Ref: 2021/91506

Shop Lane, Kirkheaton, Huddersfield HD5 0DB – application for permission to erect 48 dwellings, formation of access and associated infrastructure.

**SHOP LANE**

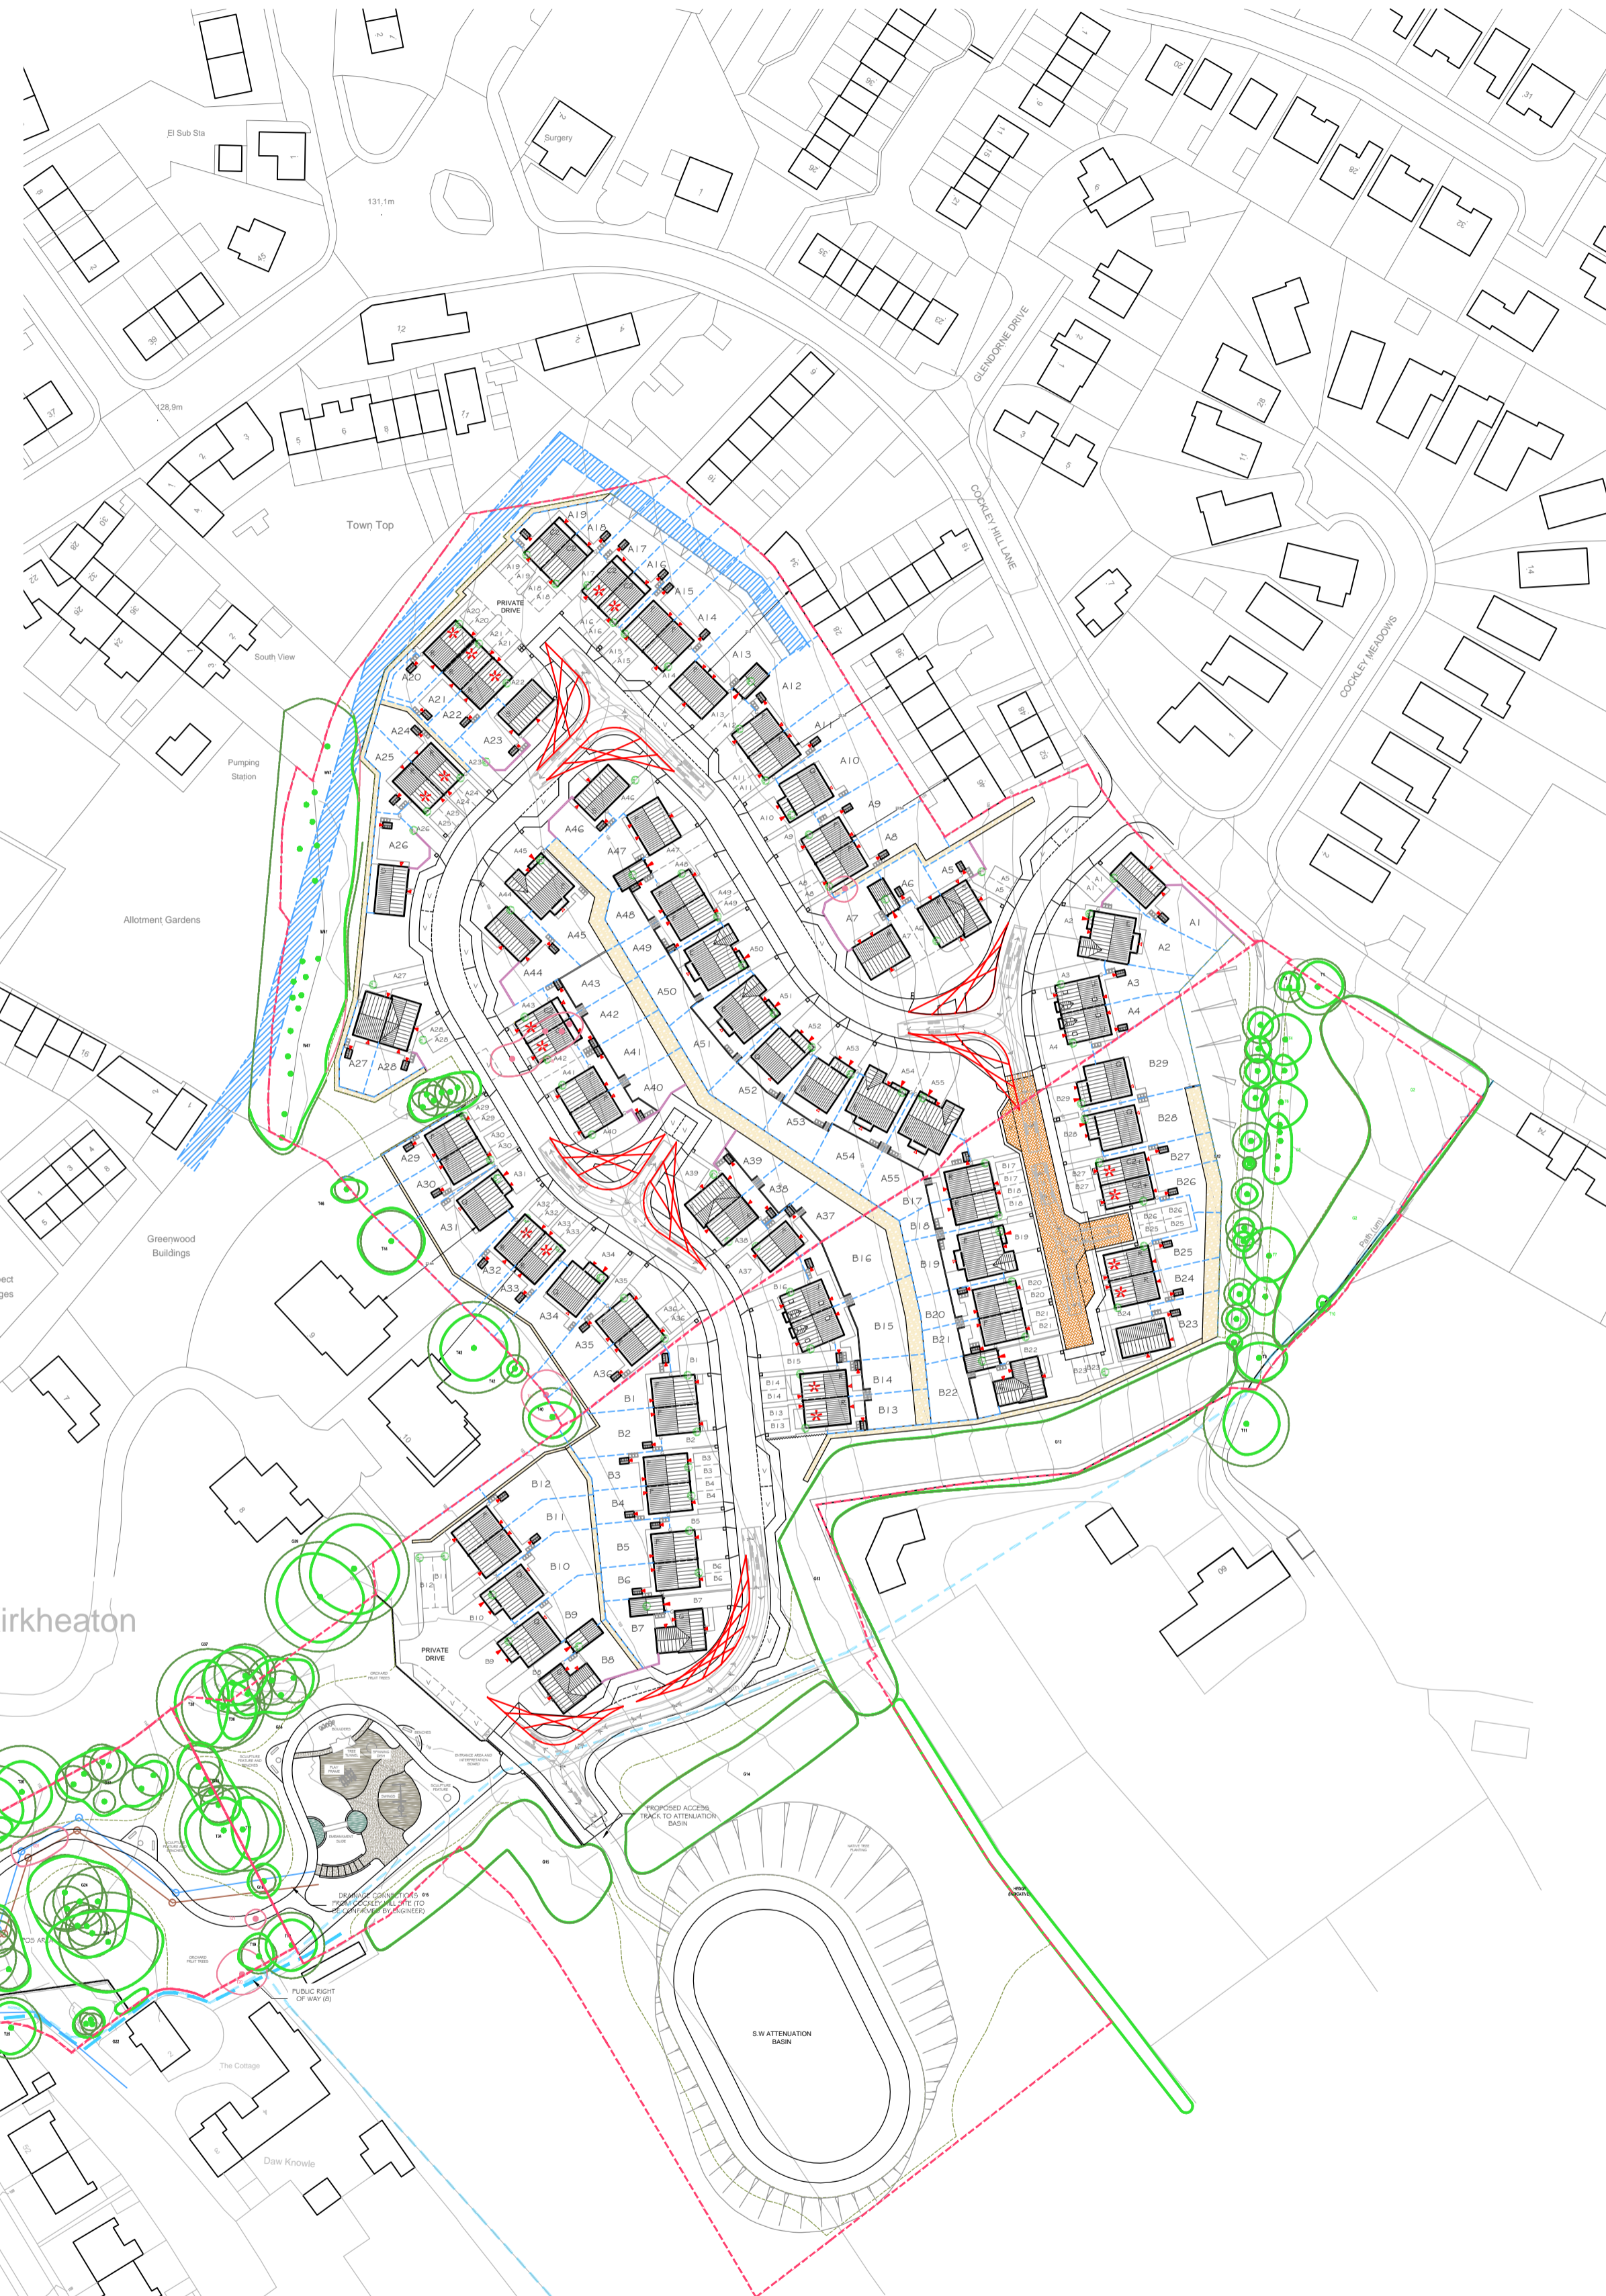
1. We note that the 2 proposed dwelling blocks planned on the site nearest to Bankfield Lane (2 blocks numbered 27, 28 and 29 and 30, 31 and 32) are 3 storey buildings. We object to the size of these buildings as follows:

- a) The height of these buildings is excessive and out of keeping with the village as a whole and with housing on Shop Lane and Bankfield Lane in particular. These buildings will be at least one storey, and in some cases 2 storeys higher than other dwellings bordering the site.

- b) The excessive height of these proposed buildings will infringe on the privacy of our house (28a Shop Lane) and other houses bordering the site - the third floor of these dwellings will look down into our garden and our living areas and bedrooms. Our house (28a Shop Lane) is a bungalow, and all our bedrooms are on the ground floor. We believe that this will be an excessive infringement of our right to privacy.

- c) These 3 storey buildings have been situated on the highest elevation on the entire site, which adds to their dominance of the area, and unnecessary infringement of neighbouring properties' rights to privacy.

2. The plans that have been submitted are misleading and confusing. From the drawings of the flats that are proposed for the 3 storey blocks (27, 28 and 29 and 30, 31 and 32) there appears to be only 2 flats / dwellings within these buildings. However, we have noted that the general plans allocate 3 separate house numbers to each of these blocks. How many dwellings will be allocated to each of these blocks?
